DOC21/1105561

EPA Advice on Environmental Impact Statement Proposed Kemps Creek Data Centre - Application SSD-10101987 707 - 769 Mamre Road, Kemps Creek.

Figure 5: Indicative generator location

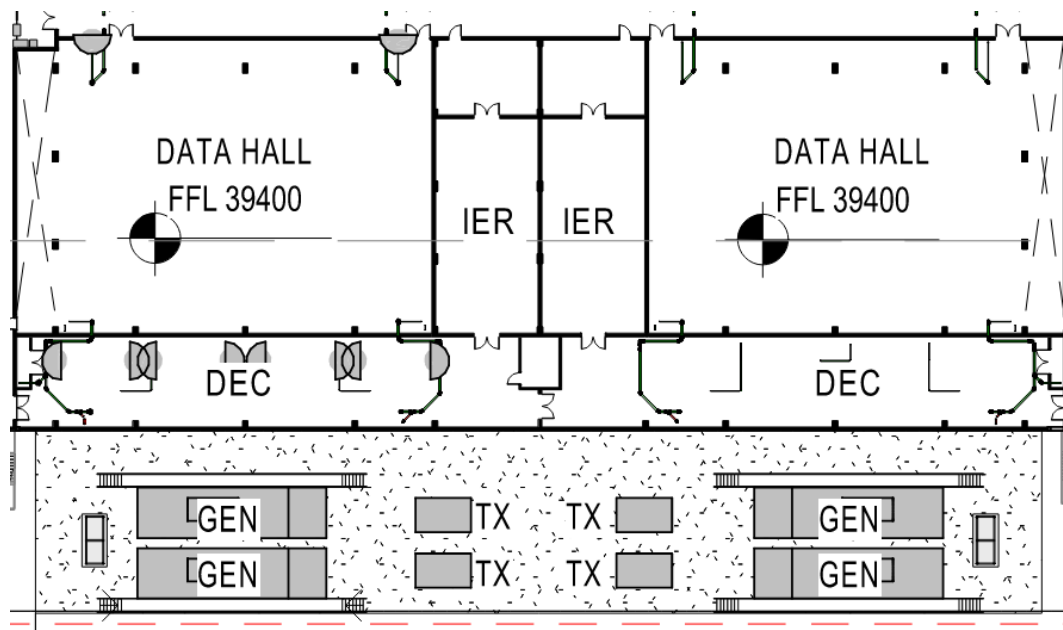
- In section 5.2 "Back-up generators of diesel storage" in the SEPP 33 Report provides an indicative render of the diesel generator and belly tank located outside each of the data halls.
- The EPA requests the Applicant include a more detailed description and/or diagram outlining
 the location and design of chemical bunding and containments so the EPA can be satisfied
 than any risk of chemical migration both onsite and offsite can be sufficiently mitigated.
